MONA OFFSHORE WIND PROJECT

Mona Examination Progress Tracker

Document Reference: S_PD_4 **F03** [F04](#)

Document Number: MOCNS-J3303-JVW-10219

Figure 1.3: Surface watercourses and NRW flood zones within the Mona hydrology and flood risk study area (sheet 1).

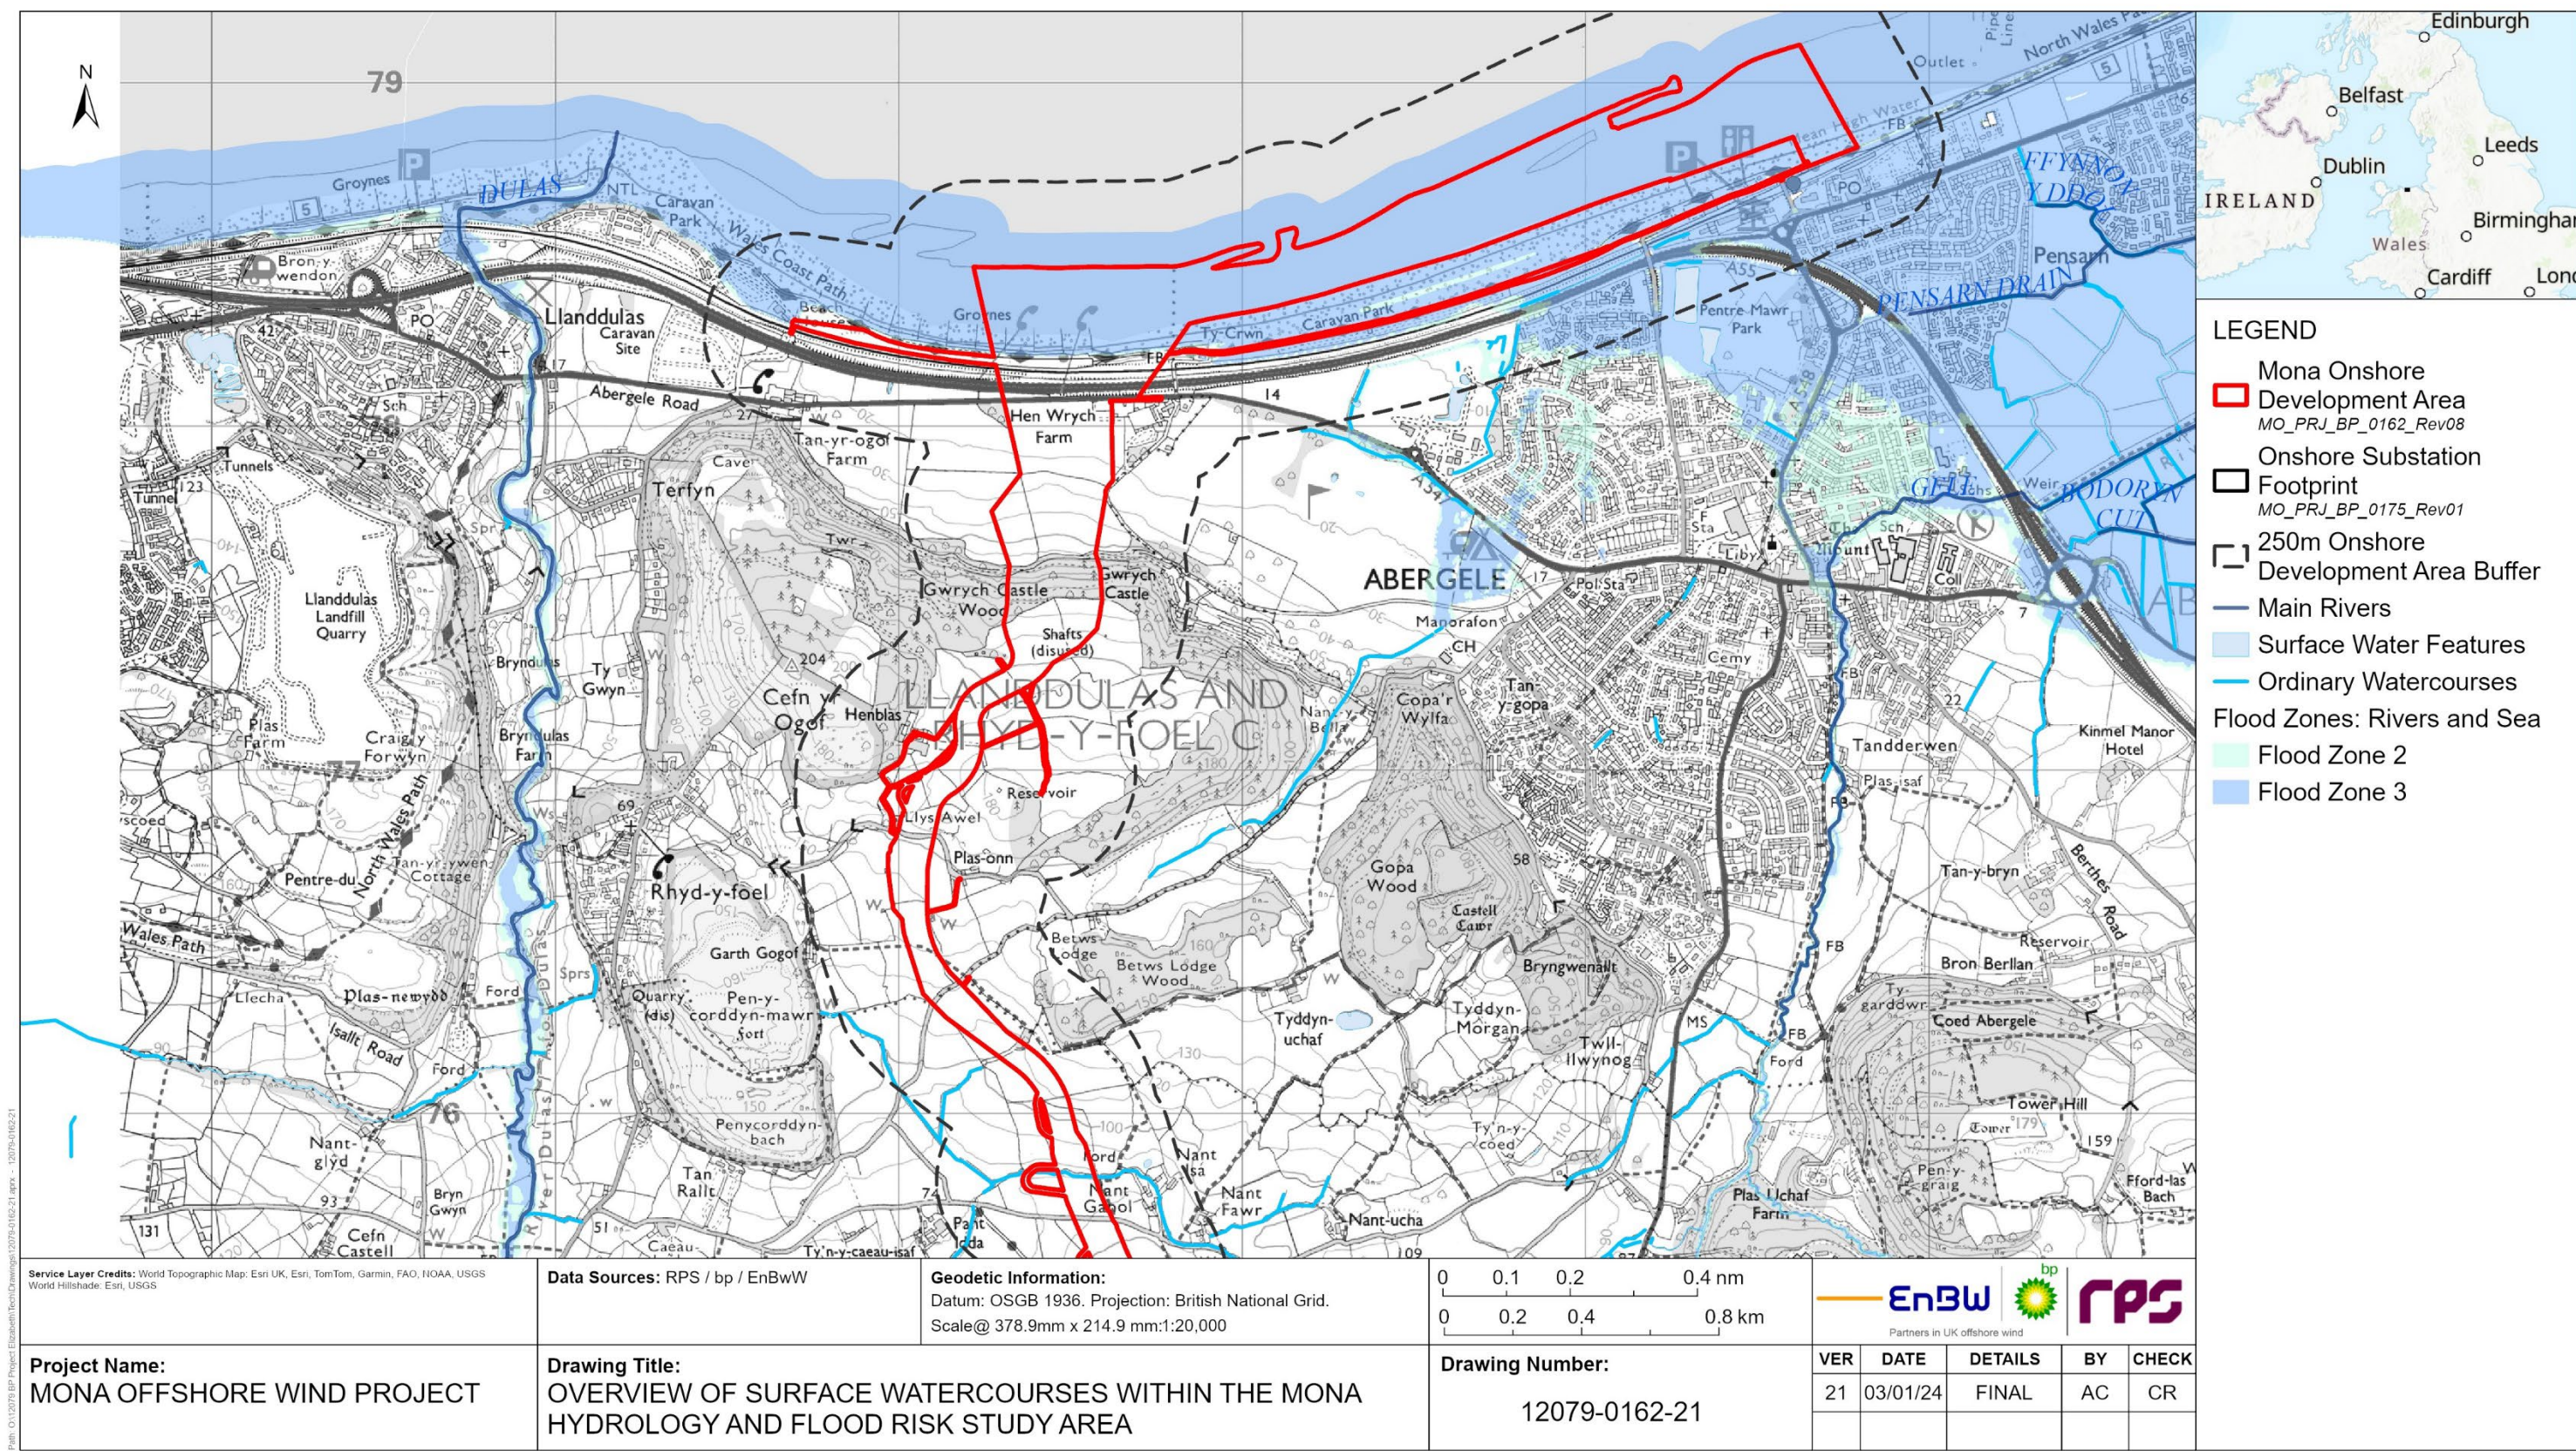
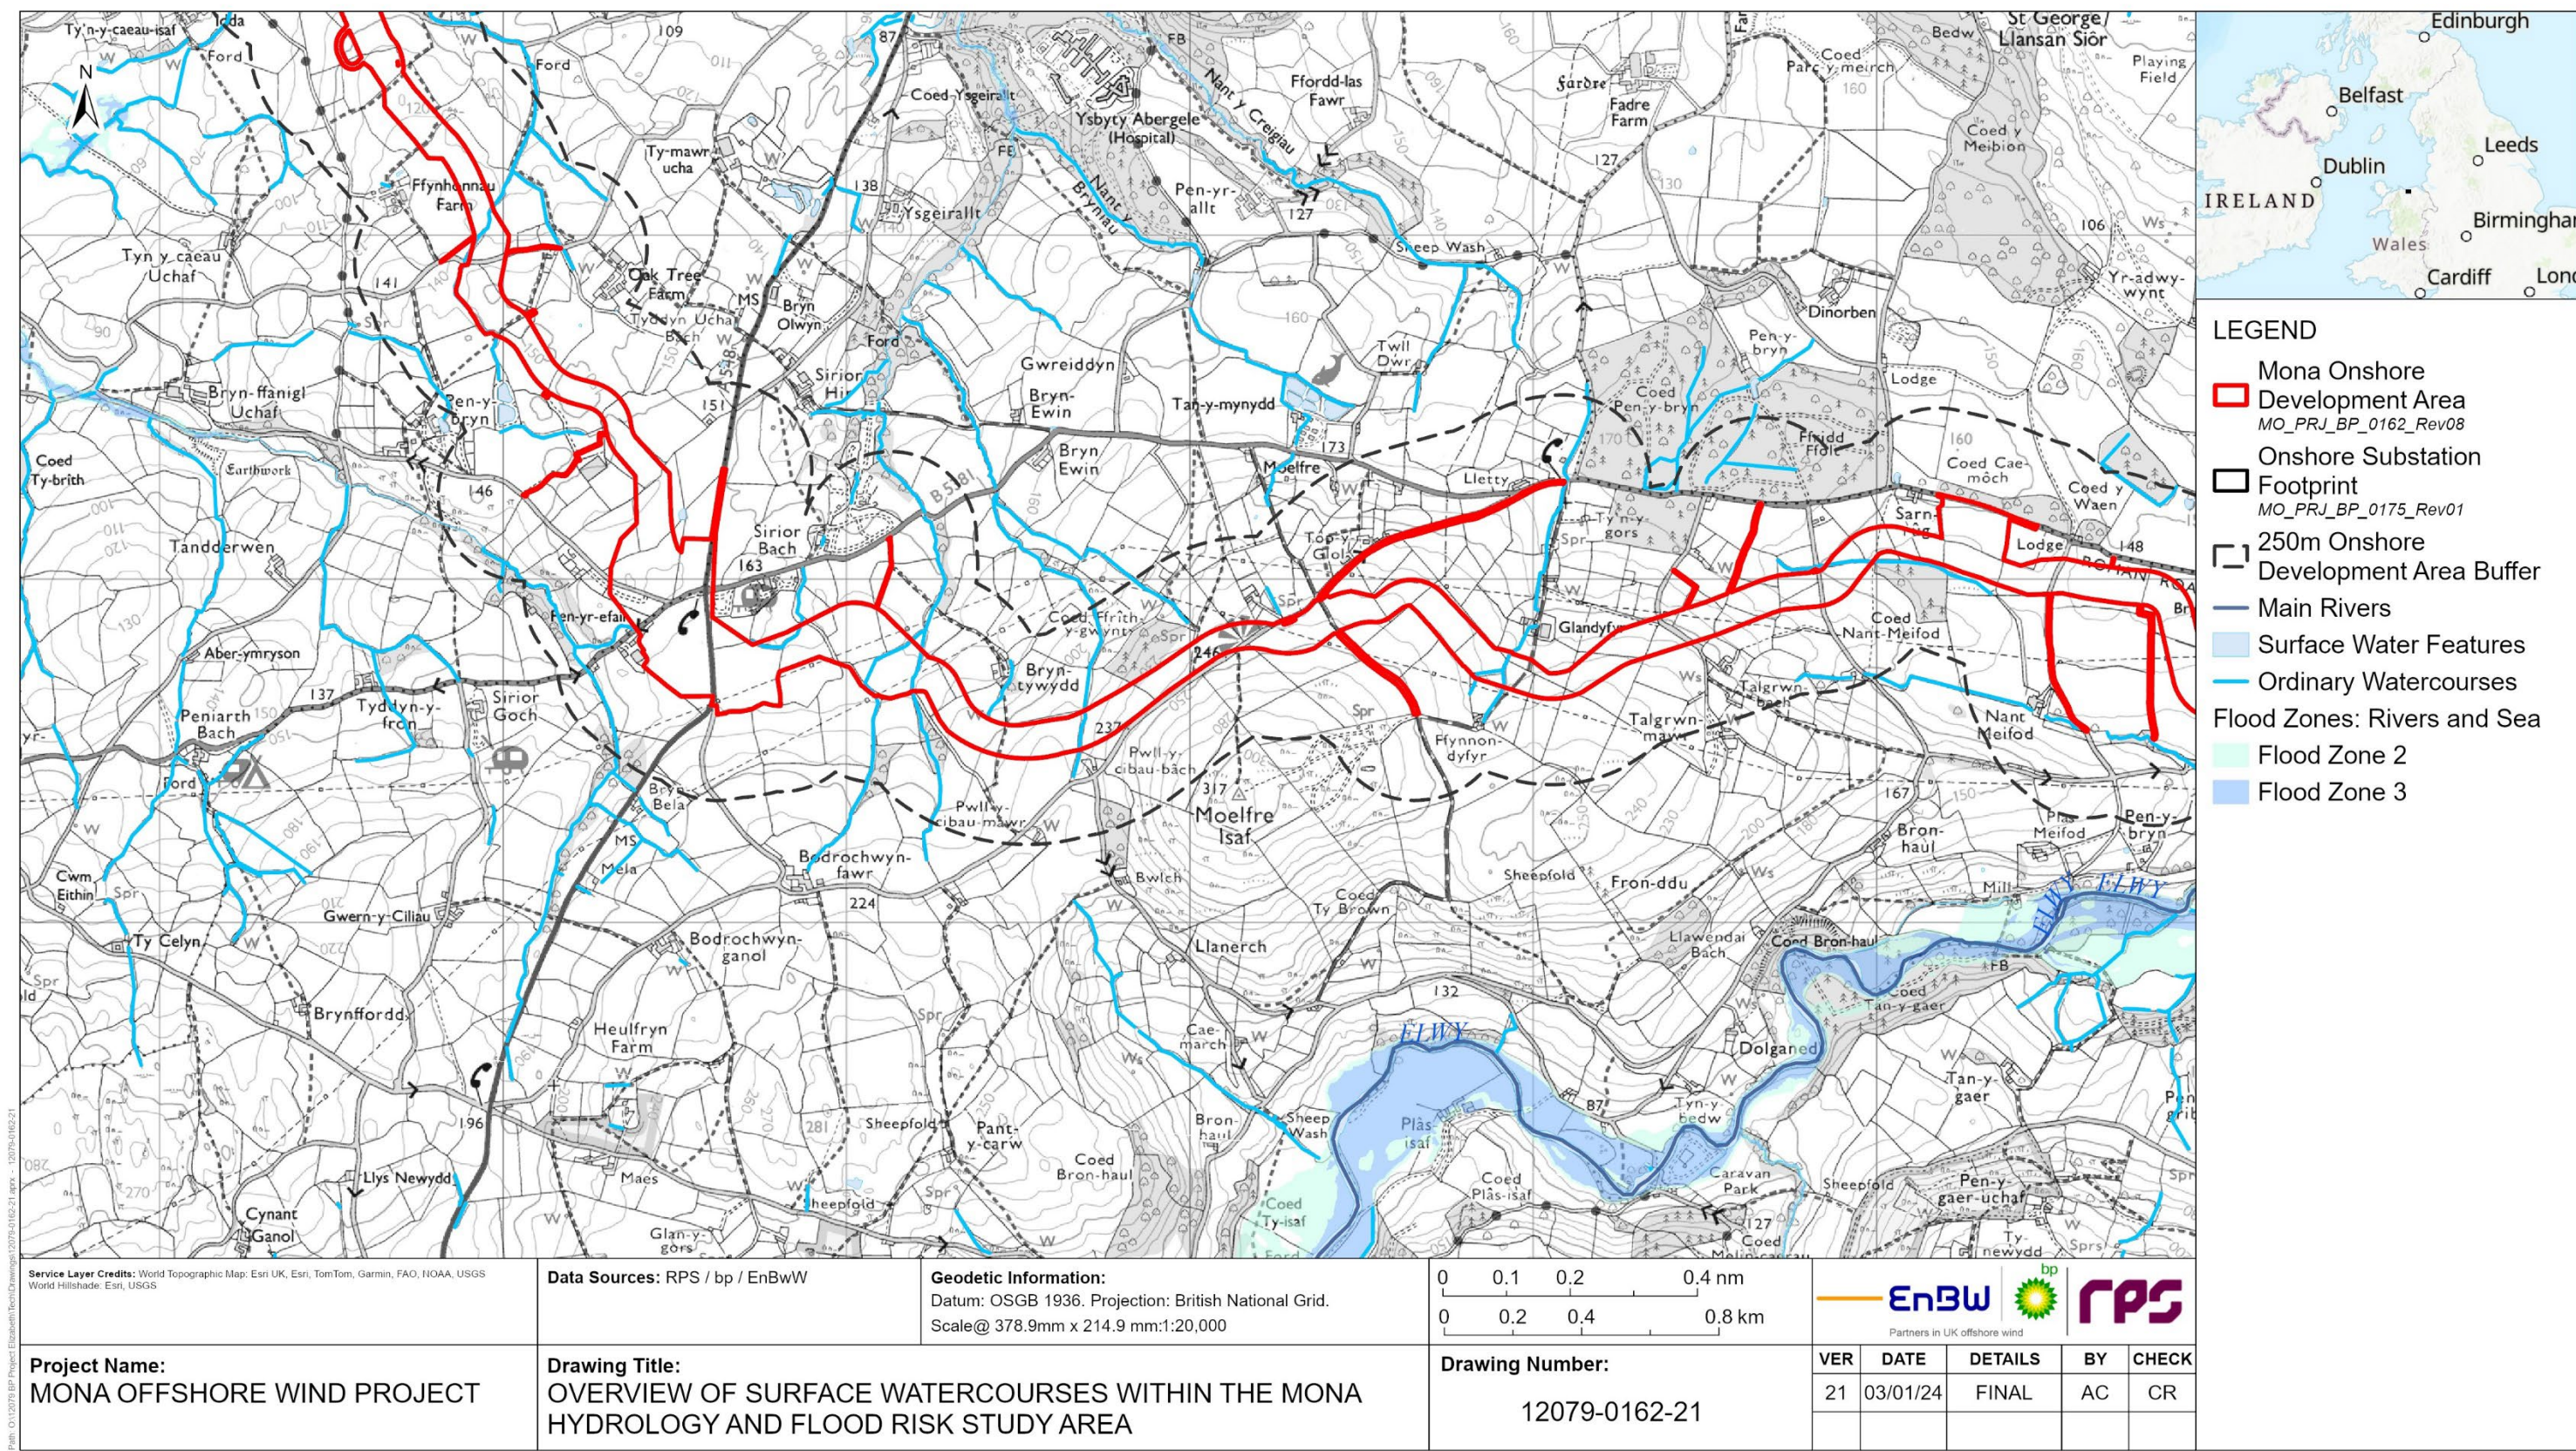
Interested Party	Principle Issues	Progress
	<p>Surface watercourses and crossings – In their relevant representation (RR-011), NRW requested updates to figures within Volume 7, Annex 2.2: Surface watercourses and NRW Flood Zones to provide clarity.</p>	<p>Green: The Applicant has responded to relevant representations (PDA-008, paragraph RR-011.138).</p> <p>NRW have confirmed through their Written Representation (REP1-056) that this response has addressed their concerns, therefore the Applicant believes this issue has now been resolved.</p> <p>This is captured in the SoCG between the Applicant and NRW (REP1-026, paragraphs NRW.HFR.01 to NRW.HFR.10).</p>
<p>CCBC</p>	<p>The Local Impact Report (REP1-049) requests further baseline data to be provided in relation to fluvial geomorphology.</p>	<p>AmberGreen: The Applicant has responded to the Local Impact Report (REP2-092, paragraphs REP1-049.72 to REP1-049.85).</p> <p>The Applicant is progressing a SoCG with CCBC (REP3-061) and the parties are in discussion regarding the crossing of watercourses, with a topic specific A meeting taking place was held on 9 October 2024.</p> <p>The Applicant has provided further information on to discuss the geomorphology baseline (S_D4_7) <u>and watercourse crossing methodologies</u> and believes this will resolve NRW's remaining comments and will update the SoCG (REP3-061) <u>subsequently the Applicant submitted a Geomorphology Clarification Note (REP4-040). The SoCG with CCBC has been updated to reflect this to Council's position that this note sufficiently addresses their concerns (S_D3_23 F04).</u></p>
